KVFR Prevention Conditional Use Permit Comments

Project: Brethren Frontier School Assembly/Gym

Permit#: CU-22-00003

Date: 09/15/2022

1061 EMERSON RD
PROPOSED MULTI PURPOSE BLDG
1" = 10'

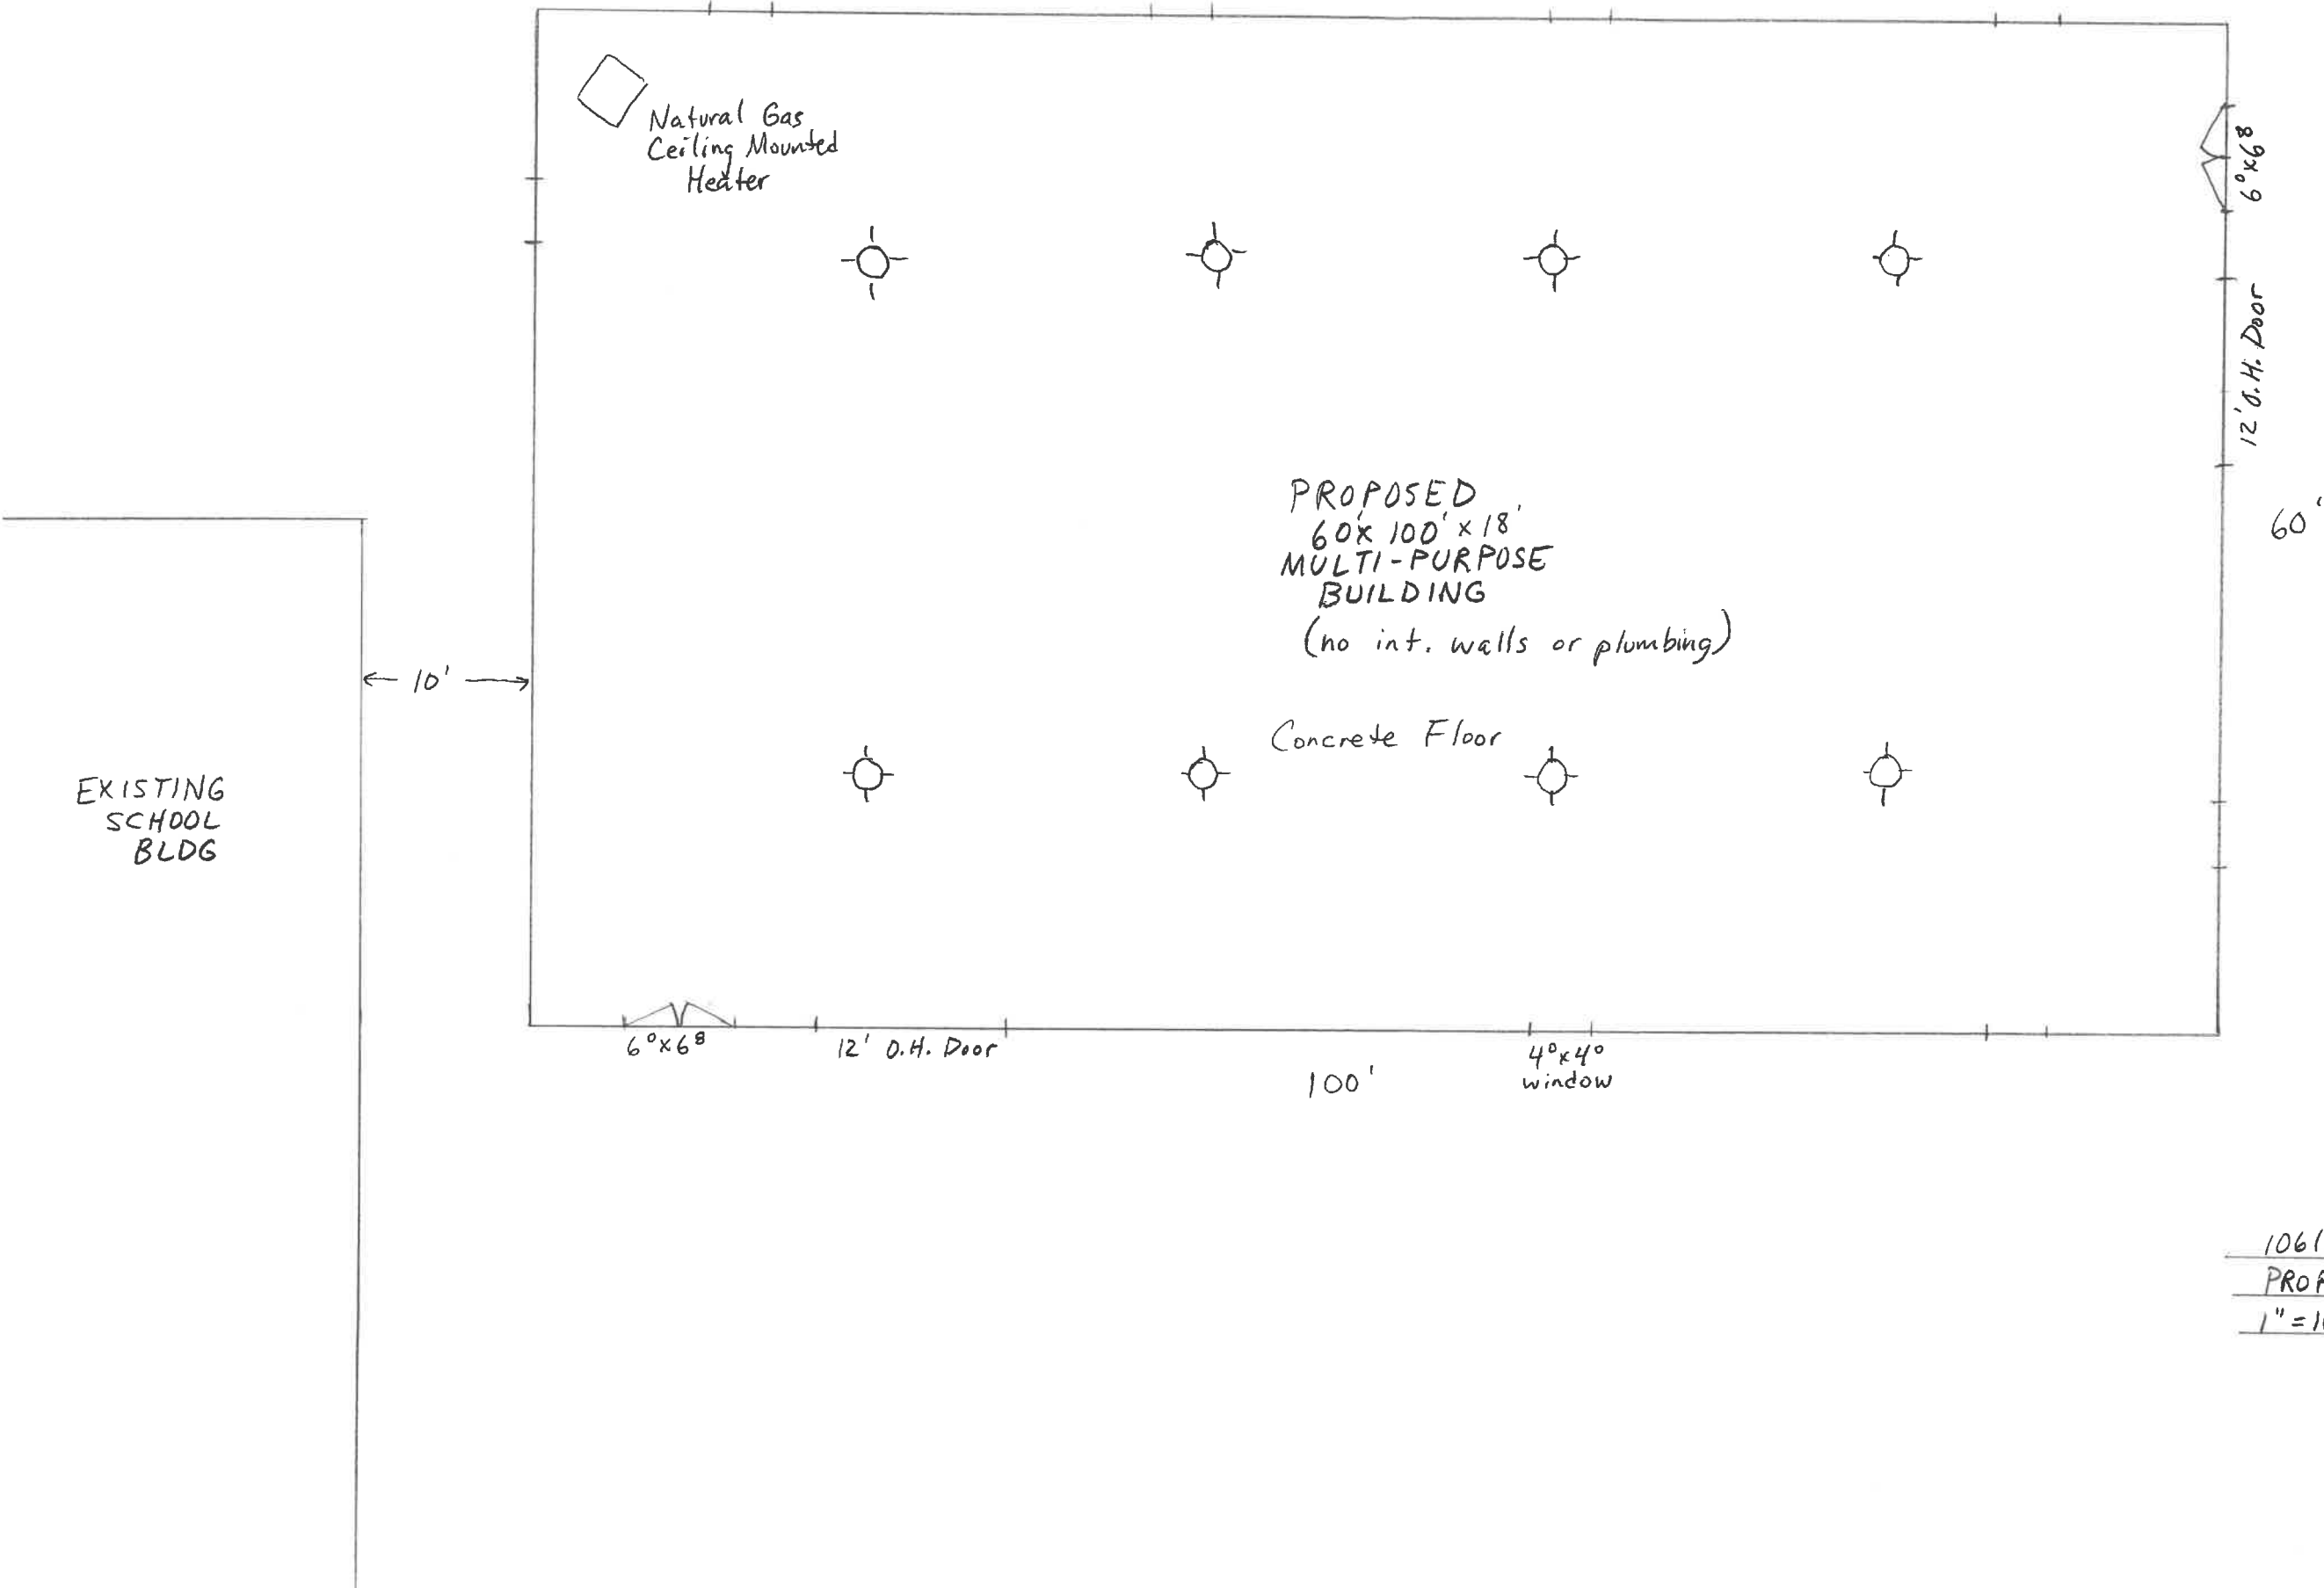
- Fire apparatus access roads exceeding 150' shall be provided with a temporary or permanent turnaround meeting the requirement 2018 IFC Appendix D.
- Fire apparatus access roads shall not exceed 10% in grade. This is especially critical in our valley's climate.
- Sufficient parking, based on occupancy and to not interfere with fire lanes and building access.
- The IFC Appendix D requires the road be a minimum of 20' wide and capable of supporting an imposed load of at least 75,000 lbs.
- Building would be required to meet IBC and IFC requirements for the occupancy to include fire sprinklers, fire alarm, exiting, emergency lighting, etc.
- Our standard turning radius is a minimum of 23' inside and 45' outside.
- Water supply meeting Kittitas County requirements.
